KITTITAS COUNTY COMMUNITY DEVELOPMENT SERVICES

February 14, 2018

RE: Mitchell Short Plat (SP-17-00003) - Request for Additional Information

SHEET 1 OF 2

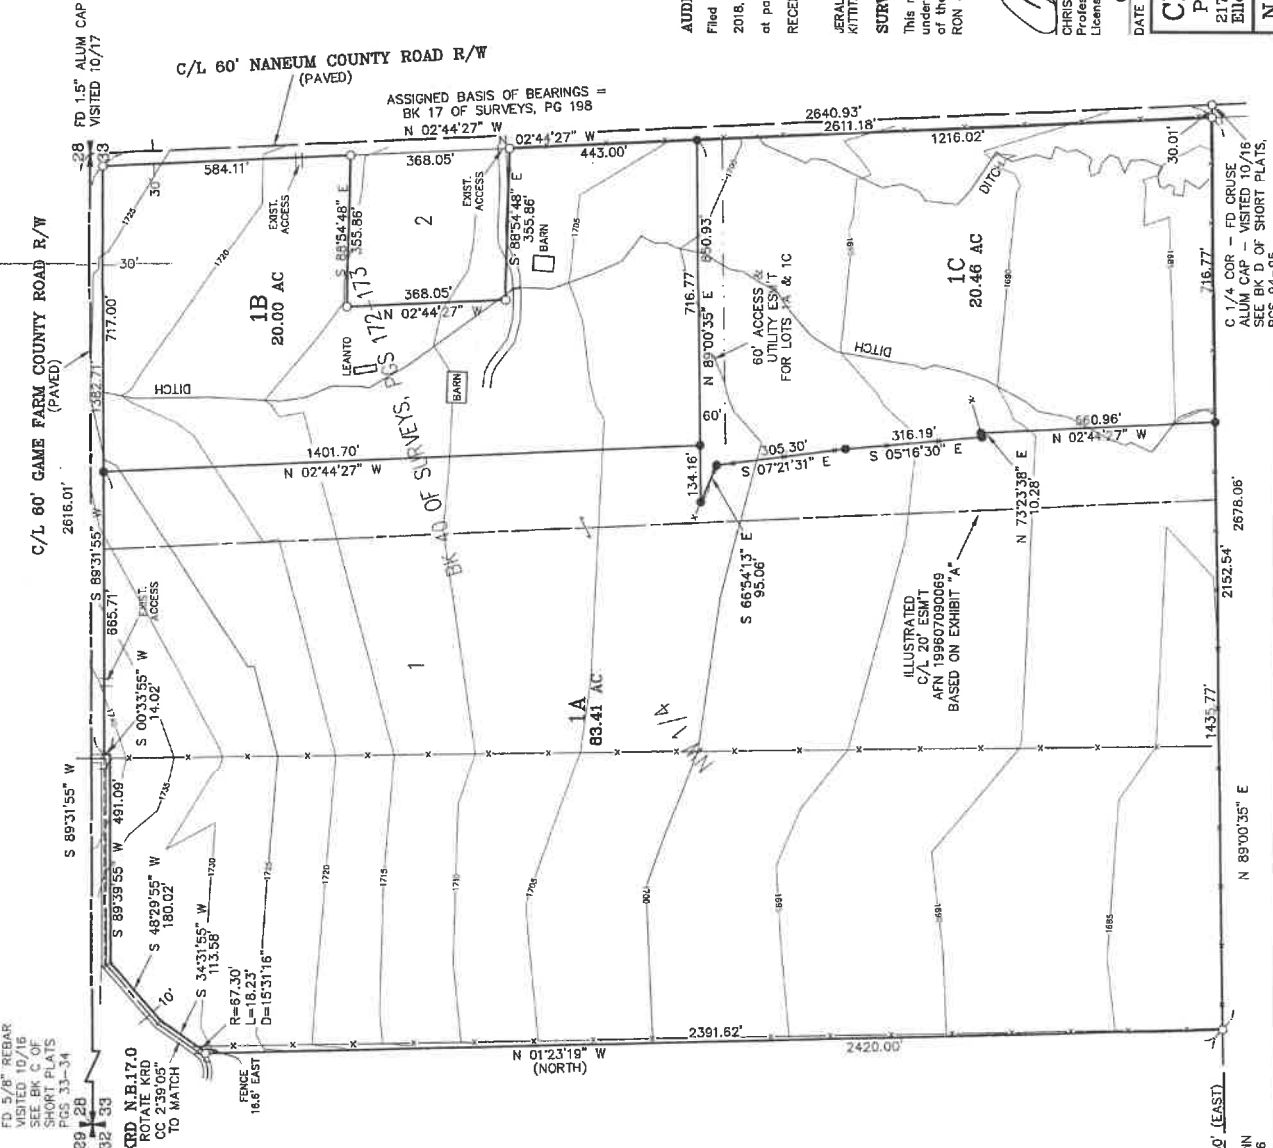
3. Provide one of the following:
 - a. A wetland/stream reconnaissance demonstrating there is a buildable area and access available for lot 1C
 - b. A new preliminary survey with reconfigured proposed boundary lines providing a building area and access to lot 1C

- c. Identification of a conservation easement on the preliminary survey over lot 1CThe county does not allow creation of non-buildable lots, nor lots that would require a variance for construction to occur based on current standards (See attached Fish and Wildlife and Department of Ecology letters).

4. Identify the shoreline buffer on lot 1A (See attached Department of Ecology comment letter)
